**Whitegates
64 Sea Lane
East Preston
West Sussex
BN16 1ND**

**YOUR REFERENCE EP/111/12
45 and 47 The Ridings and
60 and 62 Sea Lane
East Preston**

I am writing to lodge the following objections to the above proposed development, specifically with respect to the Sea Lane aspects:

SITE, BLOCK & LOCATION PLAN

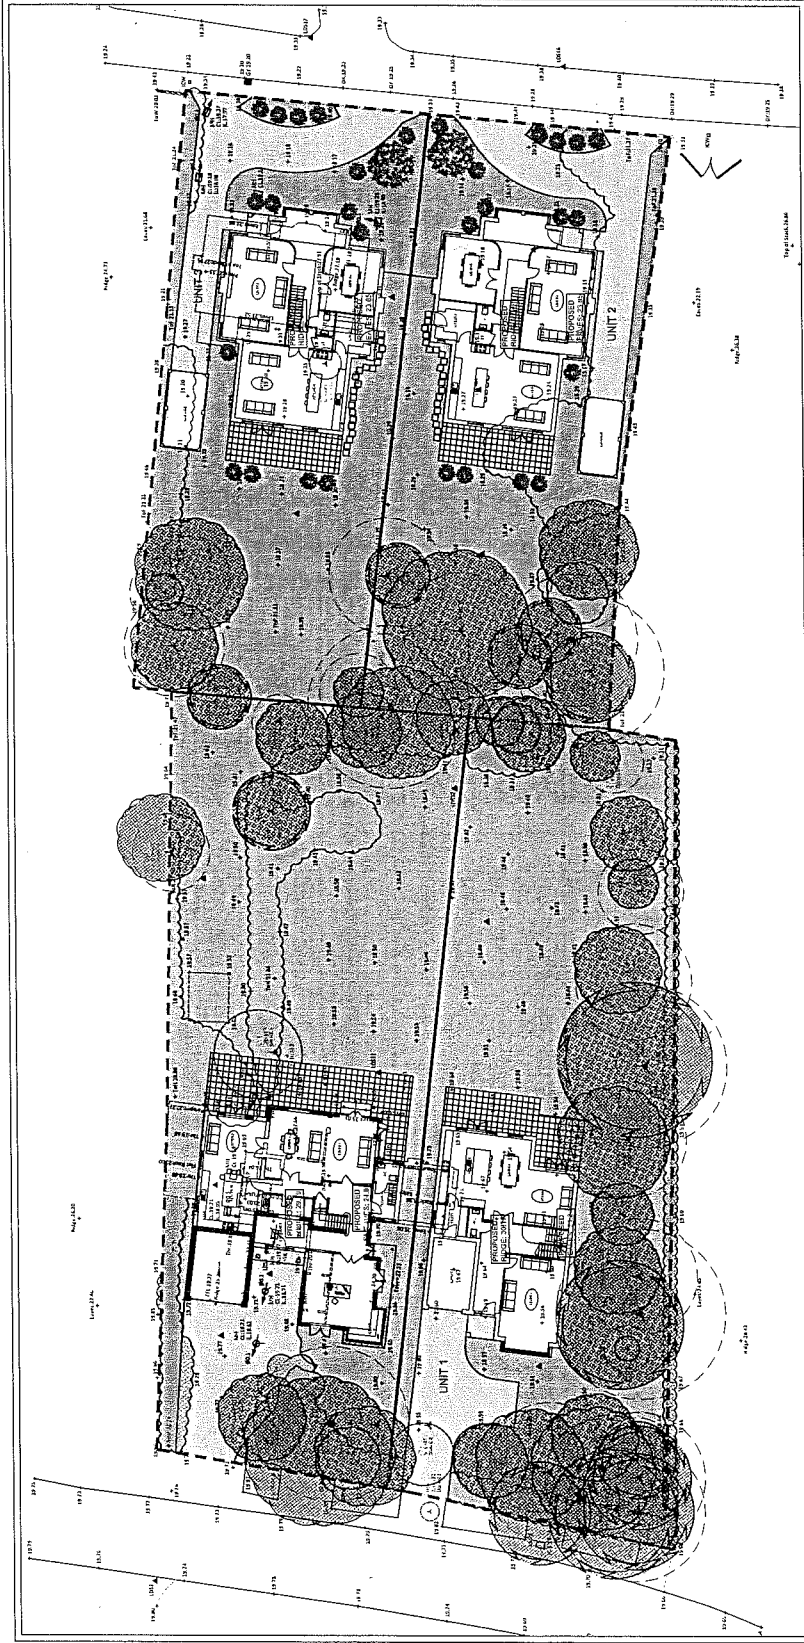
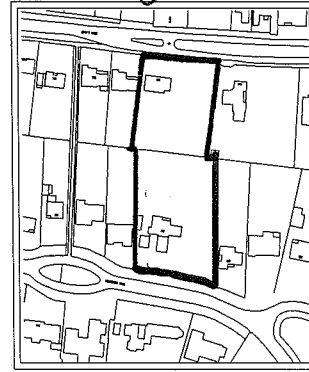
2. The plans are for a 5 bedroom house. This is not in keeping with the rest of the houses in the local area, none of which are more than 4 bedrooms.
3. The plans do not allow for adequate parking on the property itself, meaning that more than one car would have to be parked in the road. As there is no parking outside the actual property due to the grass island, cars would have to be parked in front of others' houses. The plans for the size of the house at 62 Sea Lane should be downscaled to allow for adequate on site parking for cars.
